## Application by Four Ashes Limited for an Order Granting Development Consent for the West Midlands Interchange

### The Examining Authority's written questions and requests for information (ExQ1)

Issued on 4 March 2019

Figure 12.6

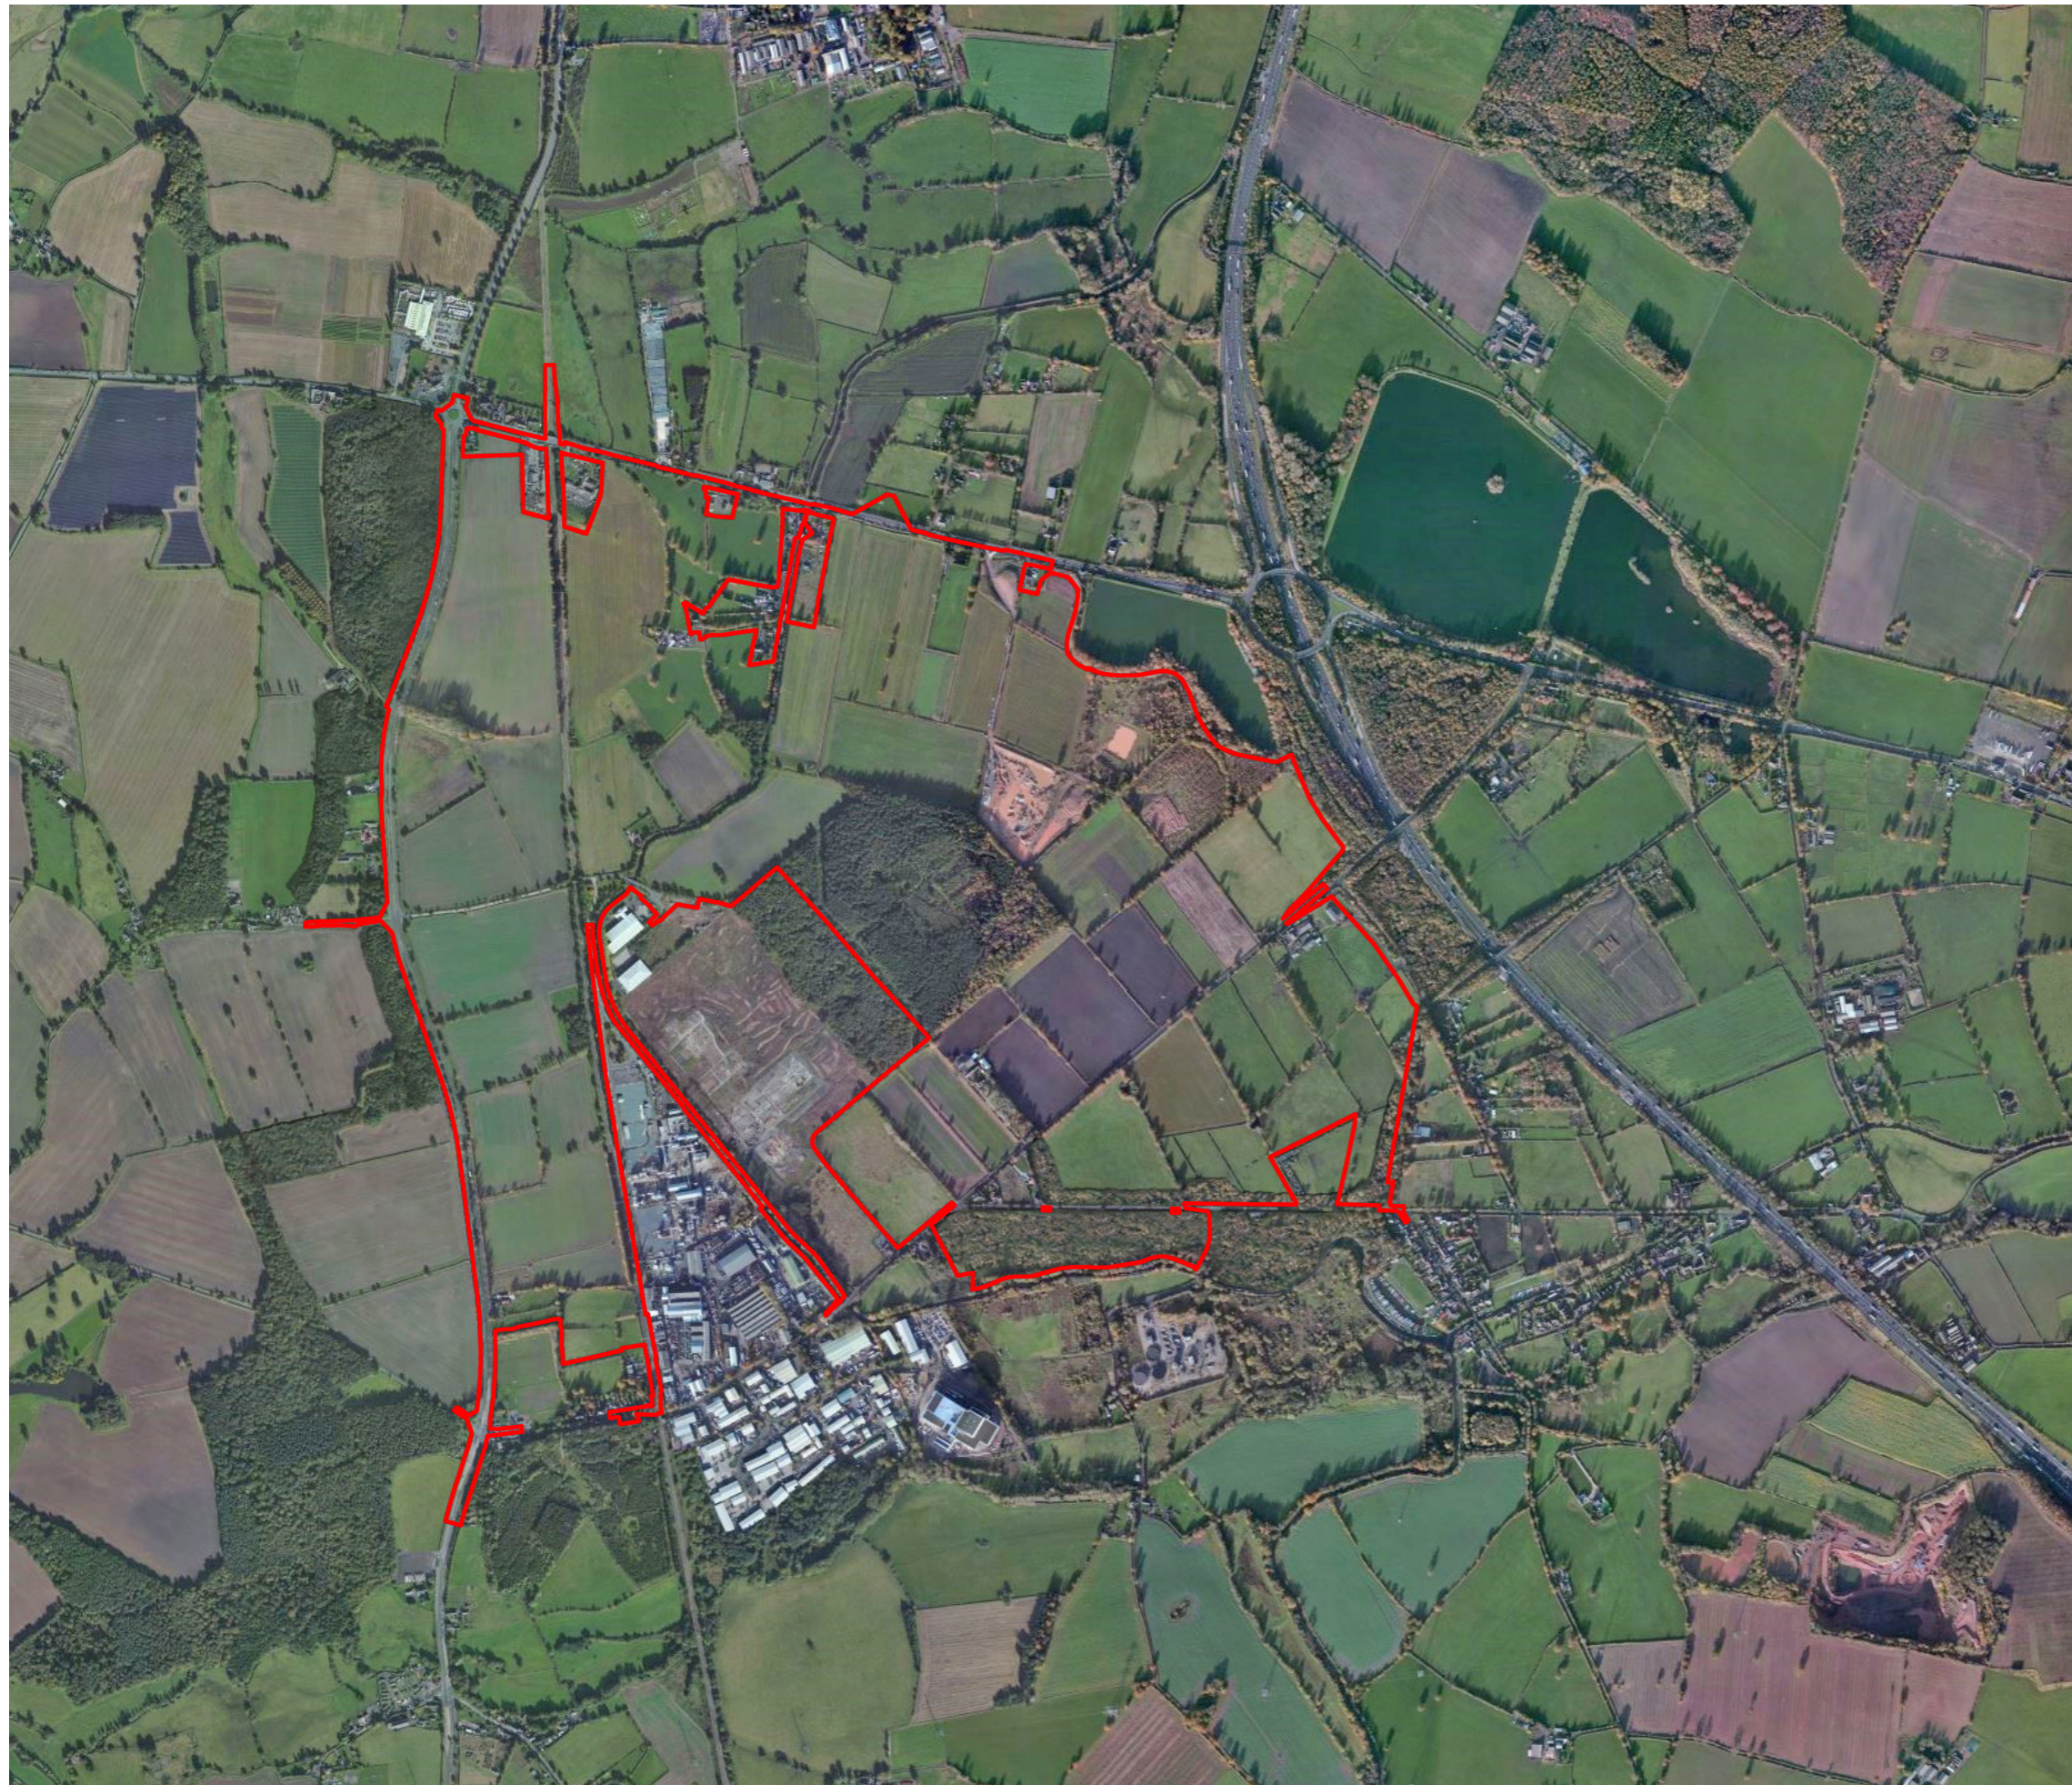
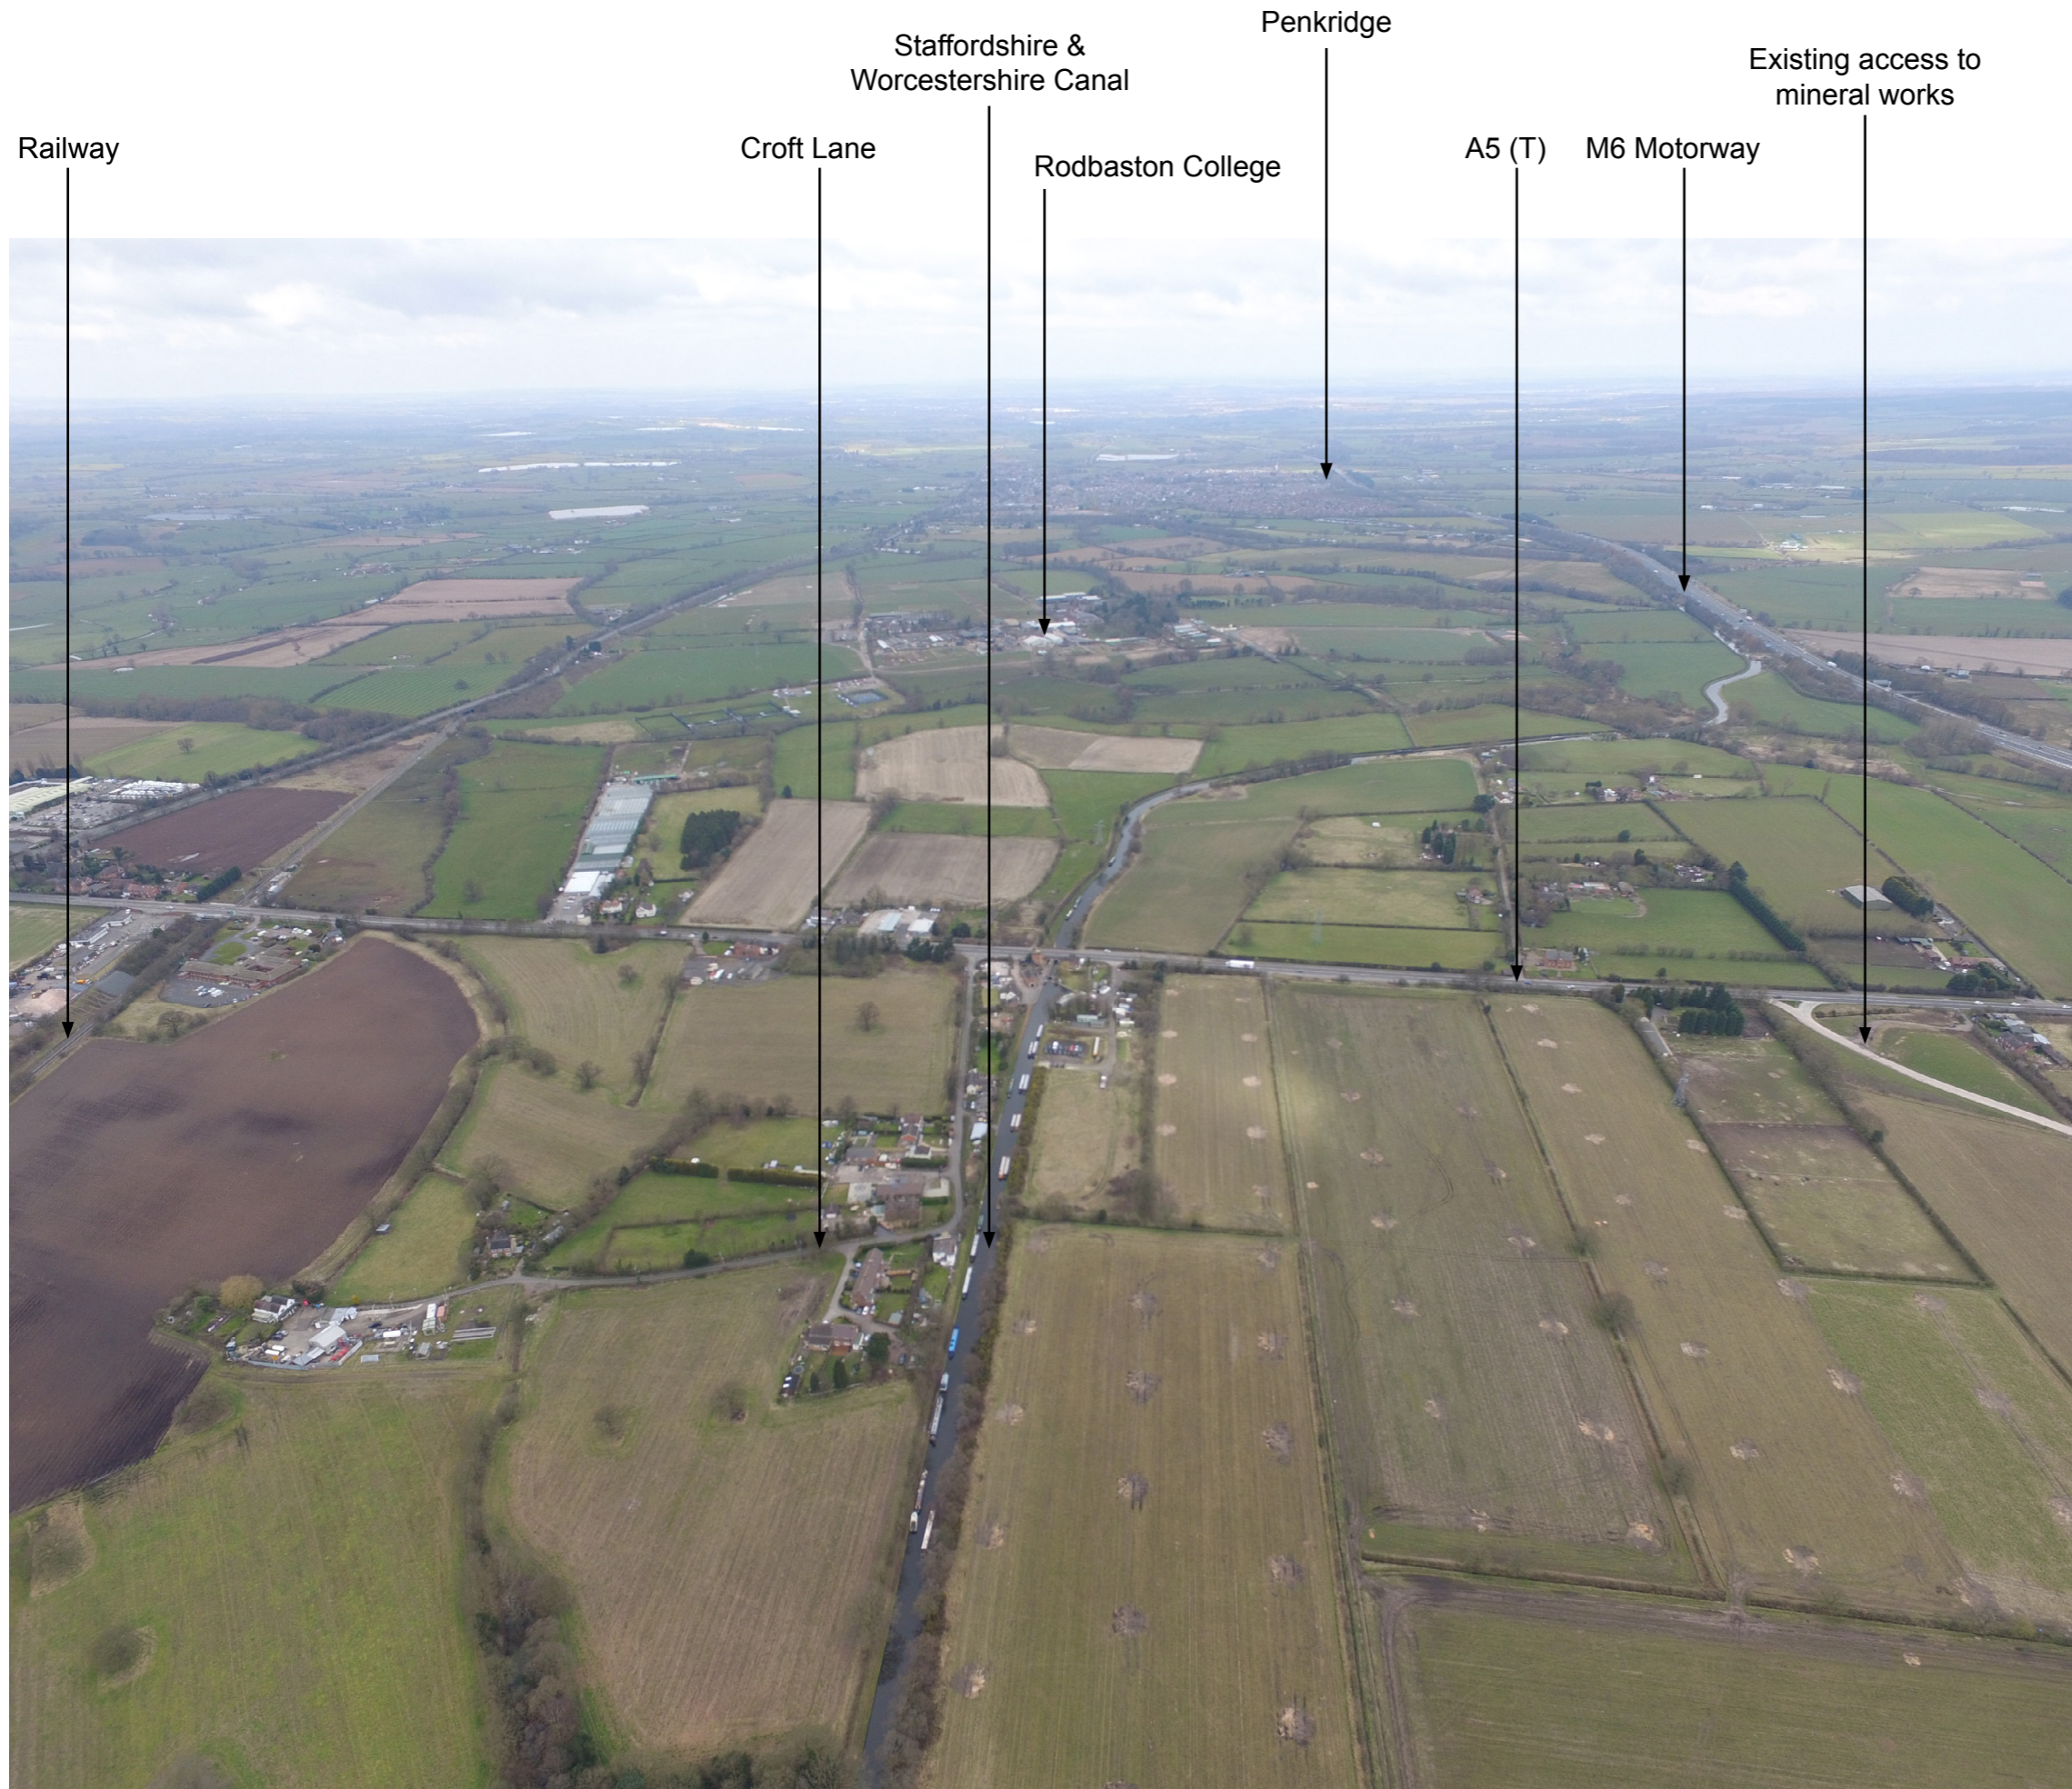
| ExQ1  | Question to:                             | Question:  |
|-------|--|--|
| 1.0.1 | The Applicant and SSDC                   | <p><b>Existing Land Uses.</b><br/>                     Some of the base plans used in the submission include the notation '<i>Caravan Park</i>' on land to the west of Croft Lane. This use is not evident on the aerial photographs in ES Figure 12.6 and does not appear to have been referenced or considered in the ES.</p> <p>(i) Does the use still exist and, if so, does it include any permanent residential use?<br/>                     (ii) If not, is there a planning permission in place or other means by which such a use could be resumed or resurrected in this location and could this include any permanent residential use?</p> |
